Application number: 2023/93305	
What is the application for?:	Erection of first floor extension above existing garage, alterations to an exist
Address of the site or building:	6, Lea Drive, Shepley, Huddersfield, HD8 8HA
Postcode:	HD8 8HA

Planning Application: 2023/93305

SOUTH WEST ELEVATION - 1:100
LEA DRIVE

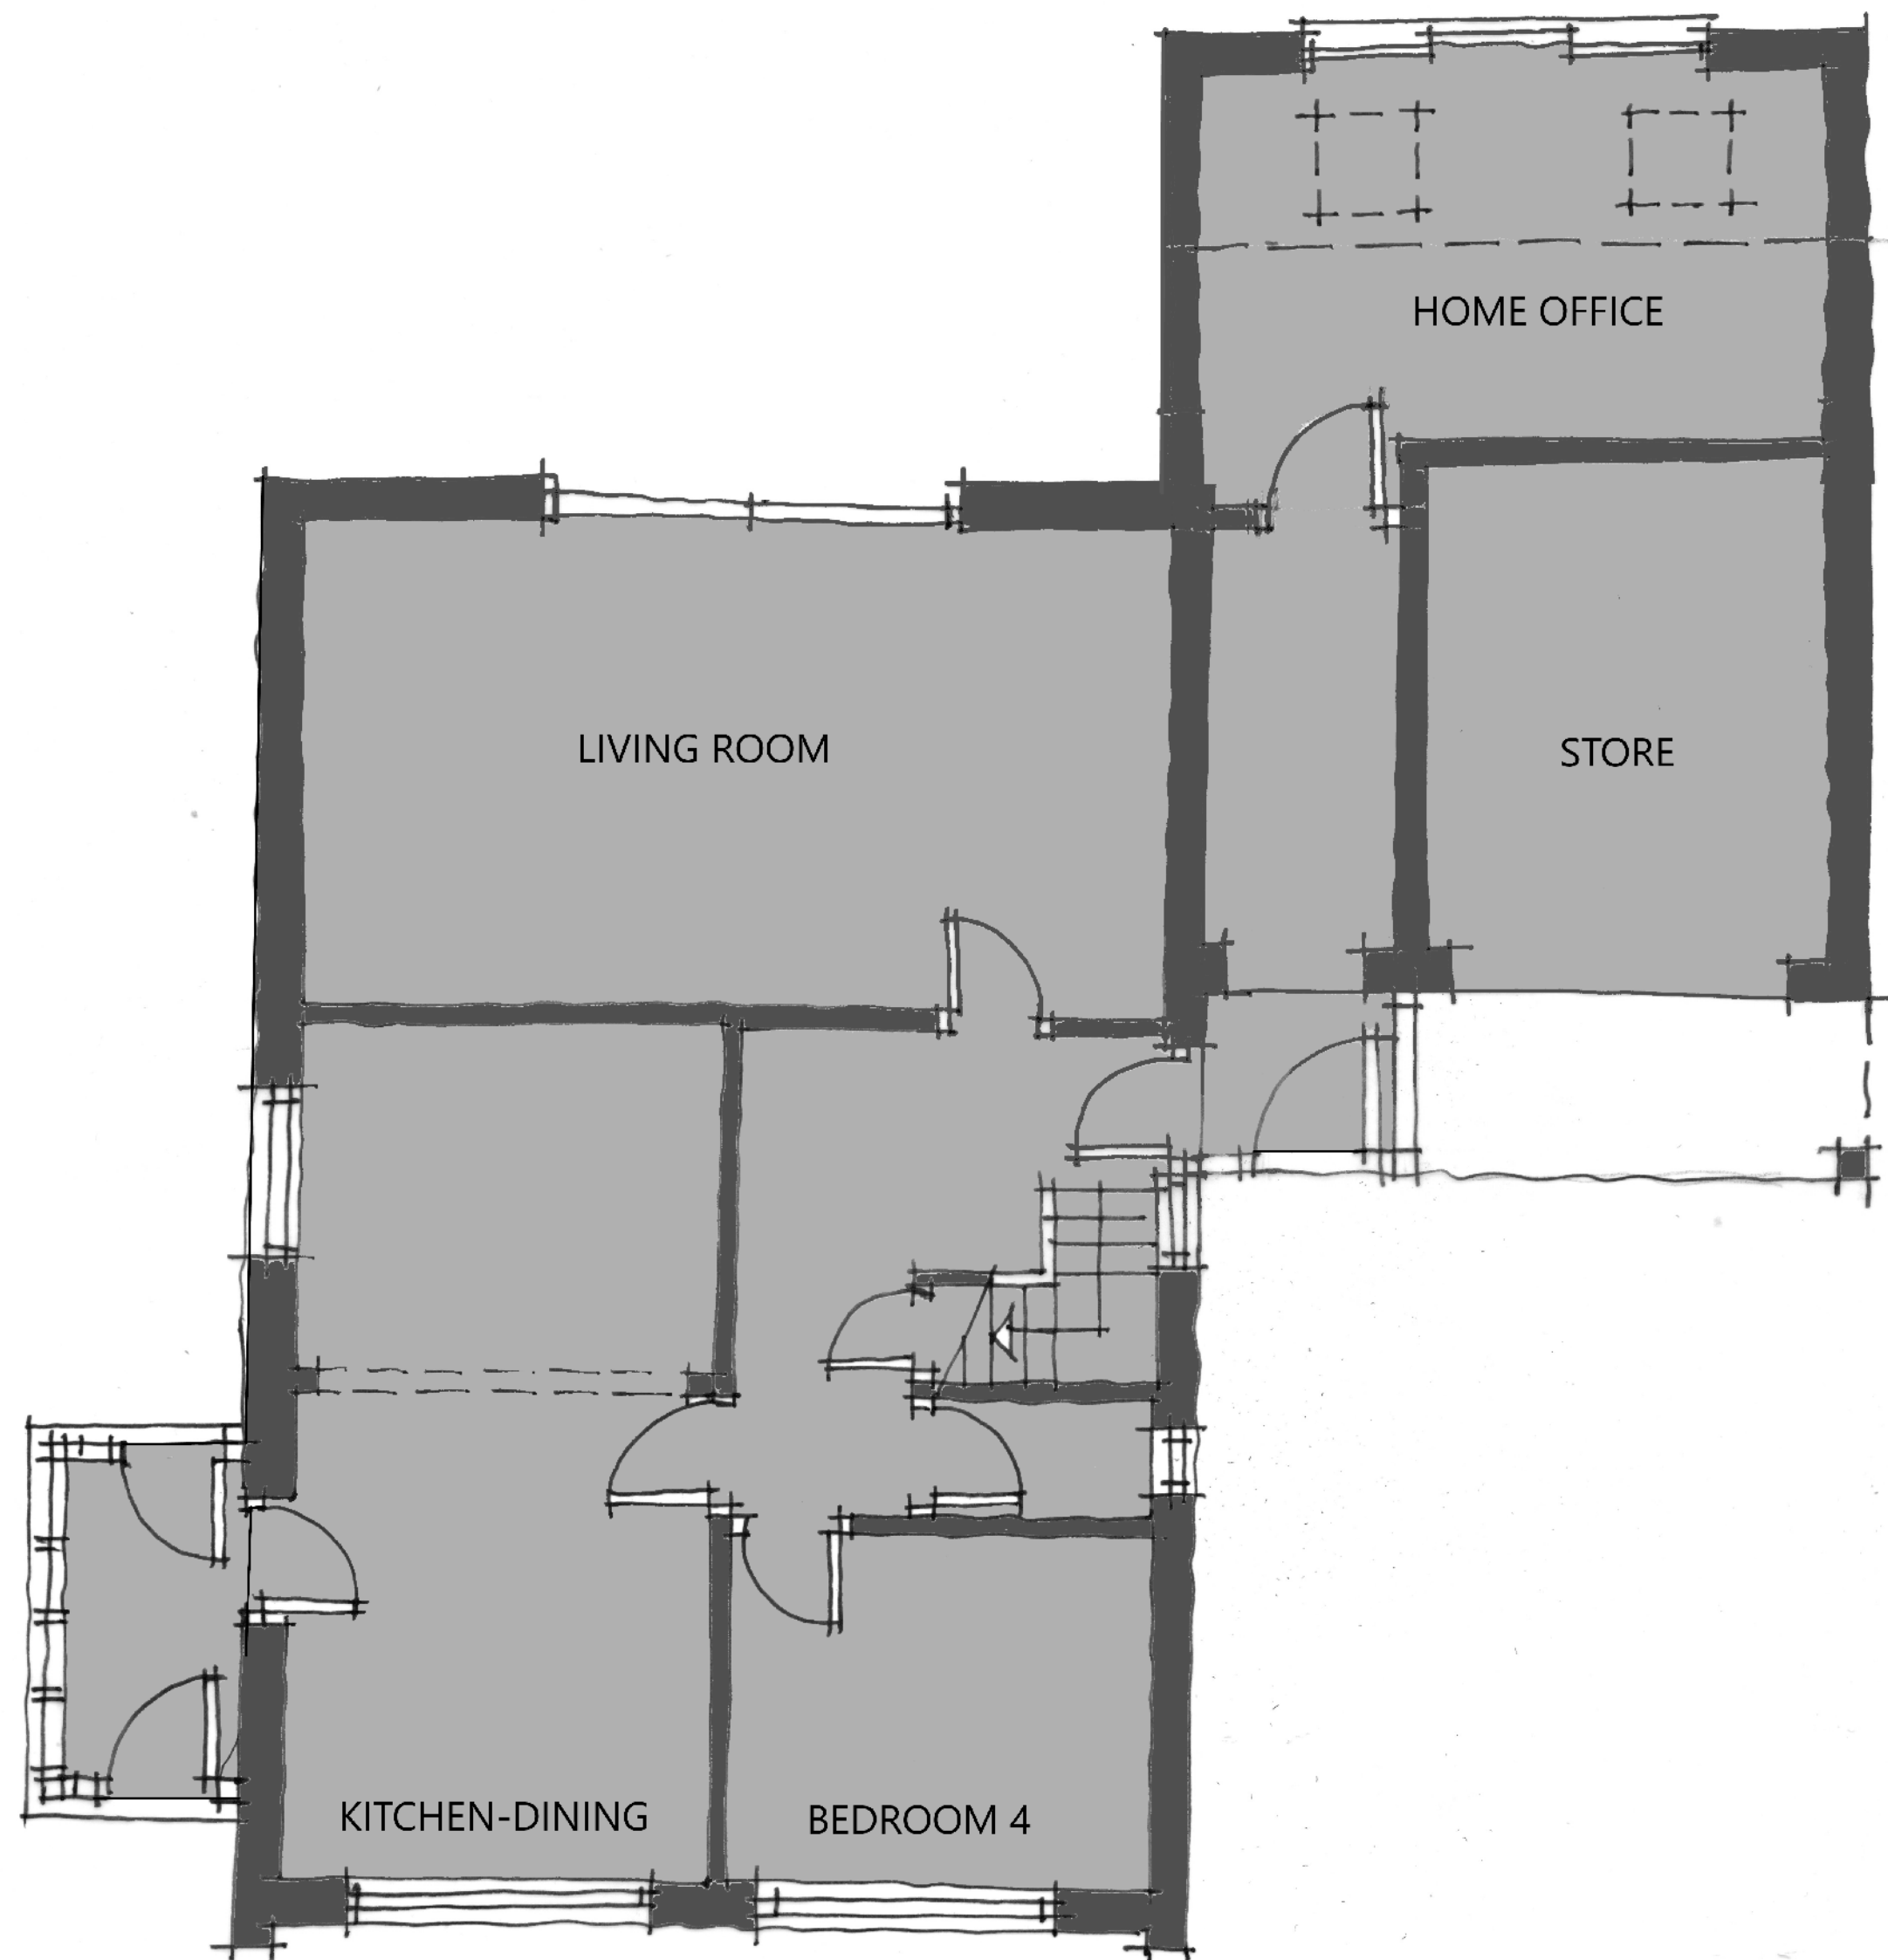
The development proposal (pitched roof, porch and large pillar) is still being brought forward considerably from the front of the garage. This is still blocking/obstructing much needed light into the main area of our home, completely overshadowing our office and partially blocking the spare room window. These are our only two west facing windows which are ground floor/bungalow (as per the photographs provided previously).

The amended plans now appear to have an additional four first floor windows directly facing the bungalow section of our home (completely compromising any privacy we have for the 2 west facing large side windows of the bungalow).

Additional two large first floor north facing windows, which look straight into our rear garden, removing any minimal privacy we currently have.

All the windows on the first floor of the proposed plans will overlook our property. No consideration has been taken to the privacy or invasion into our dwelling/home.
